**Application for a non-material amendment following a grant of planning permission,
Town and Country Planning Act 1990**

**Non material amendment to previous permission 2024/90423 for erection of two
storey side extension**

98, Listing Lane, Littleton, Liversedge, WF15 6EZ

Application Number: 2026/91183

Drg No 24 13 Rev A

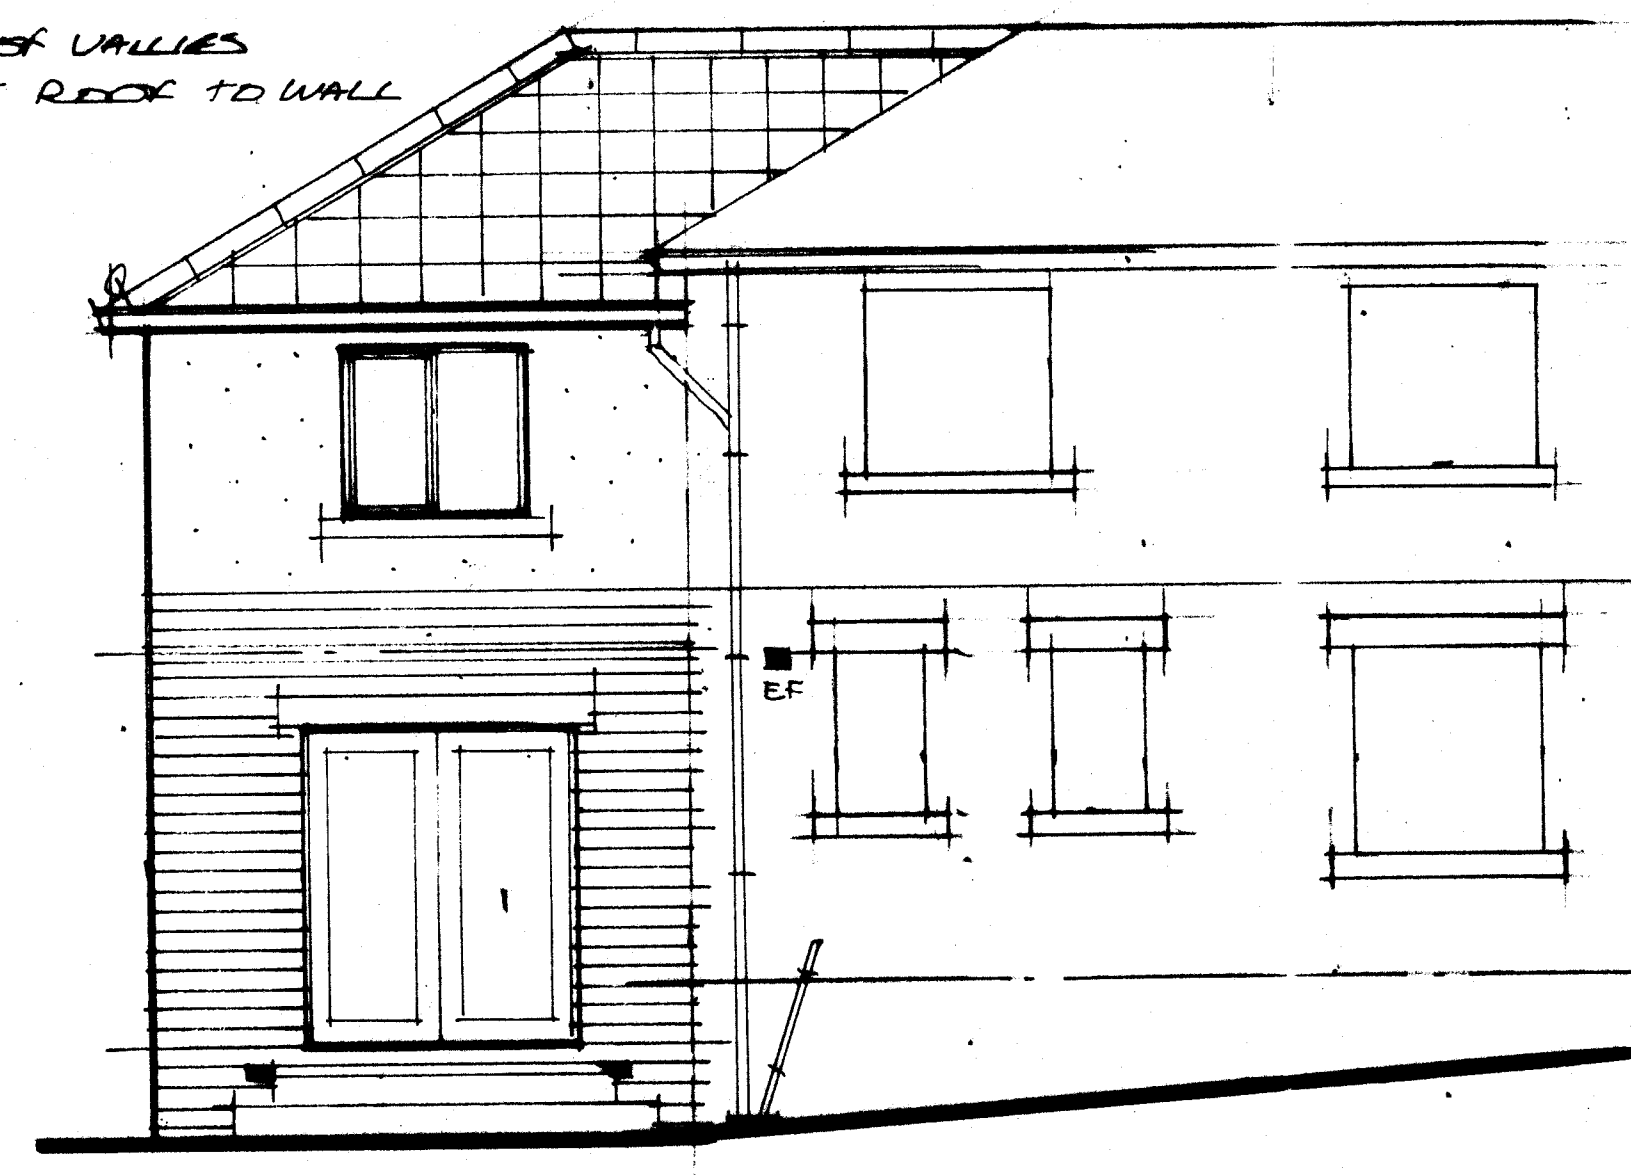
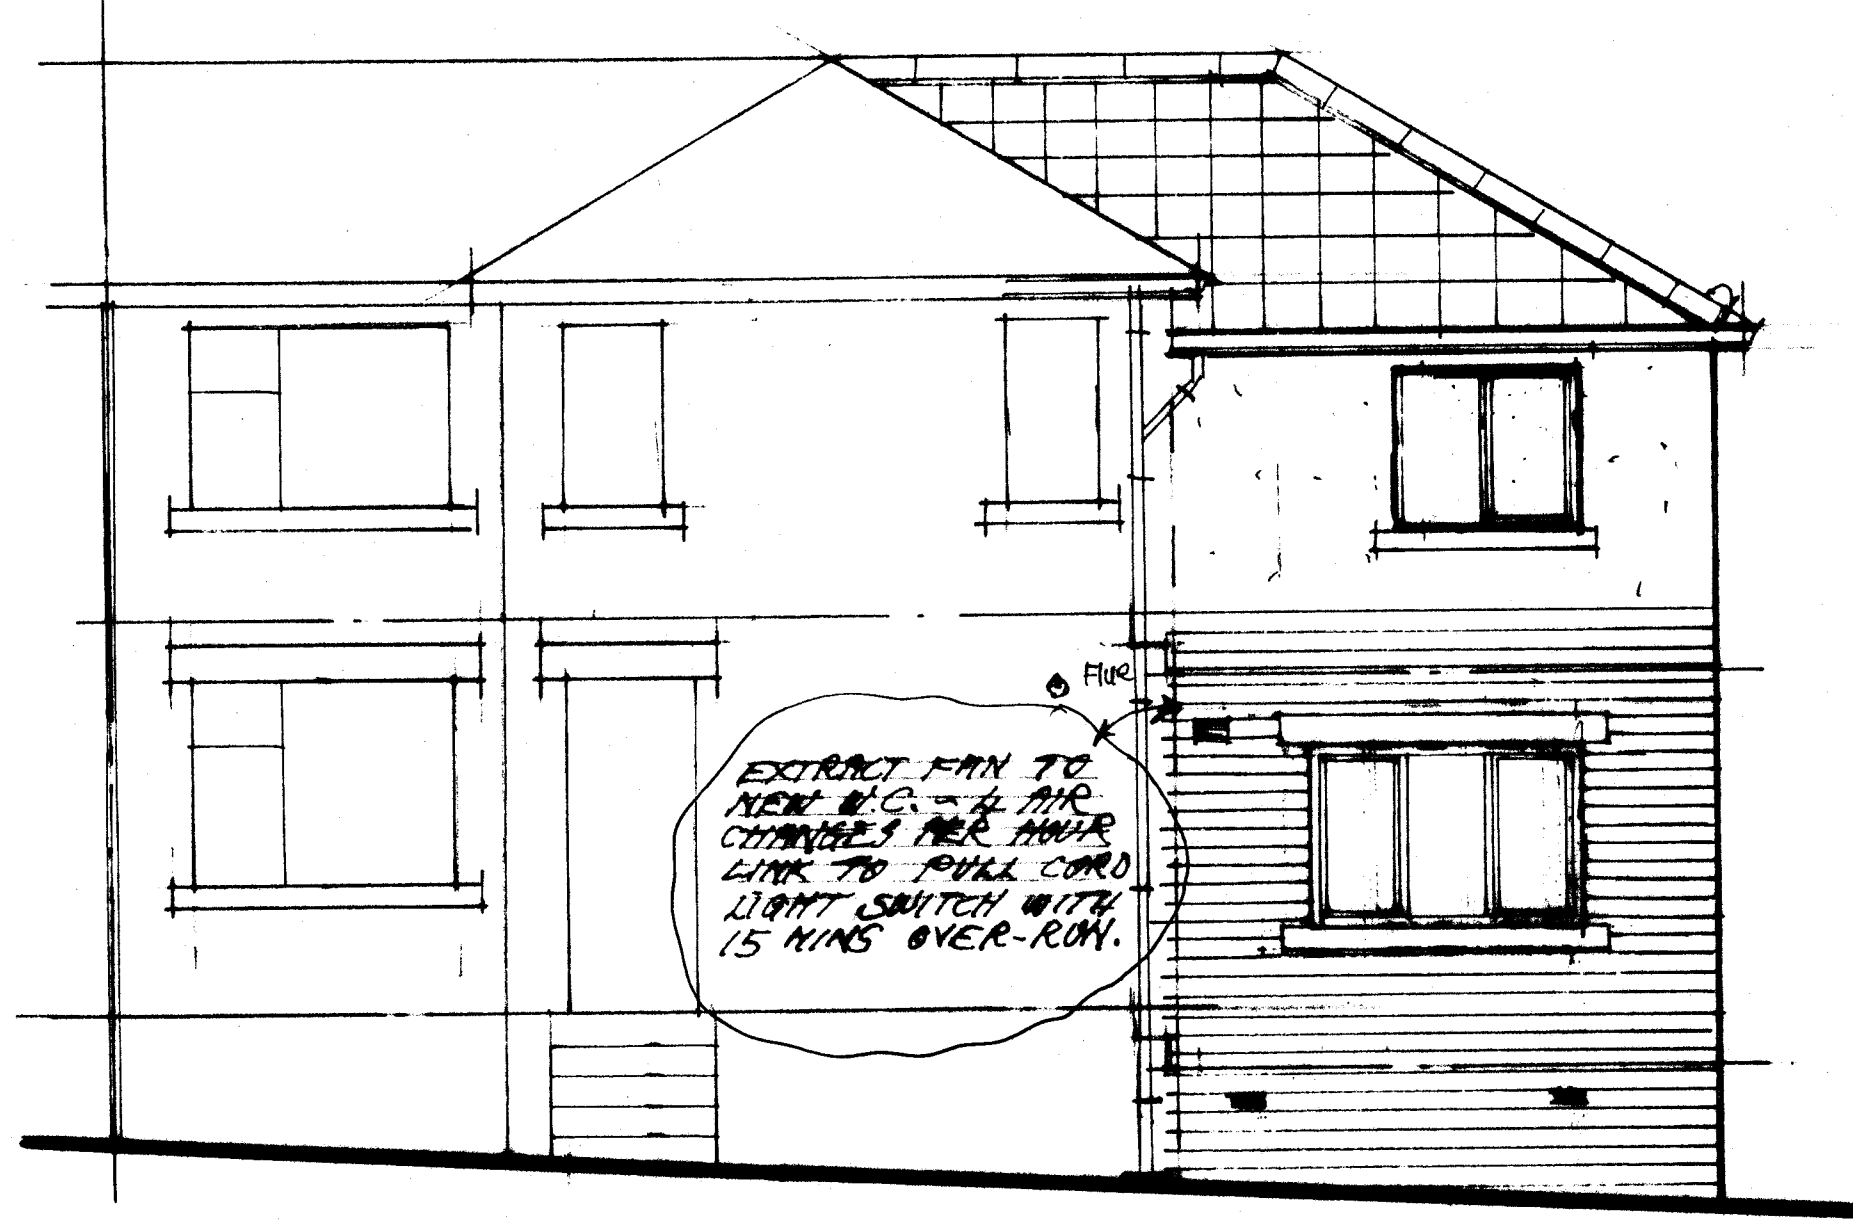
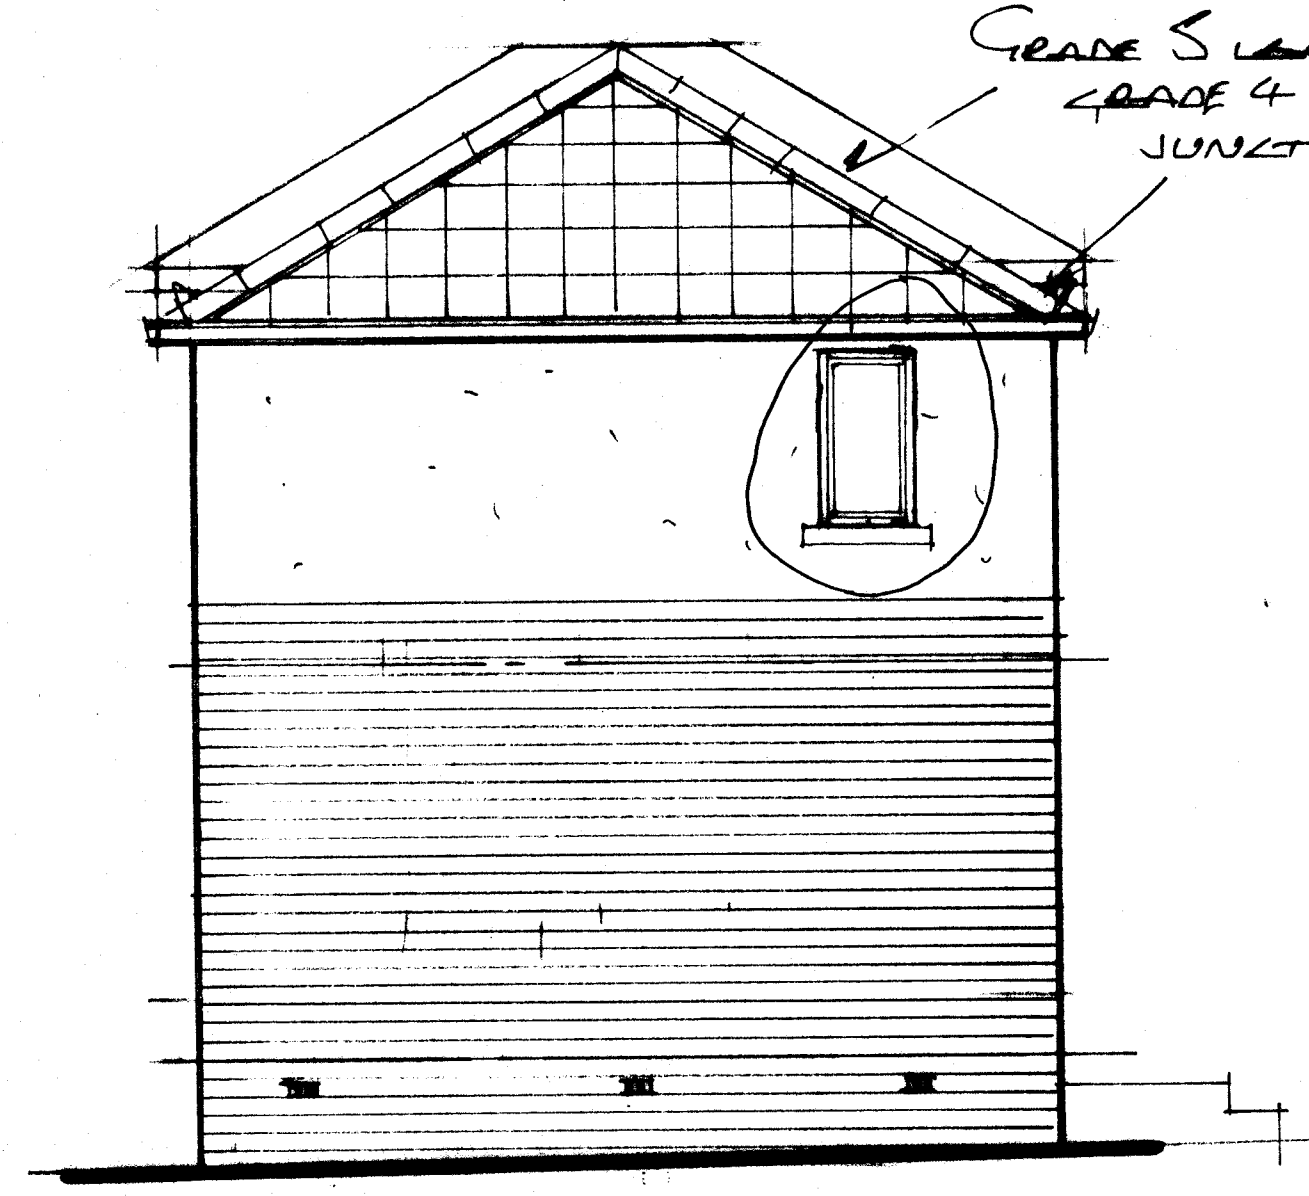
Thank you for your application dated 30-Apr-2026 for a non-material amendment to the above scheme. The amendment sought is the inclusion of a window on the side elevation of the two storey extension as indicated on drawing 24/13 A – Proposed.

I confirm that the alterations are acceptable and may be considered as a non-material amendment to the approved drawings. It should be noted that this letter relates only to the non-material amendment sought and it is not a re-issue of the original planning permission. The two documents should be read together and as such, all conditions imposed on the original granting of planning permission apply to the proposal as now amended. A copy of this letter and the amended plans will be retained on the public record of approved documents.
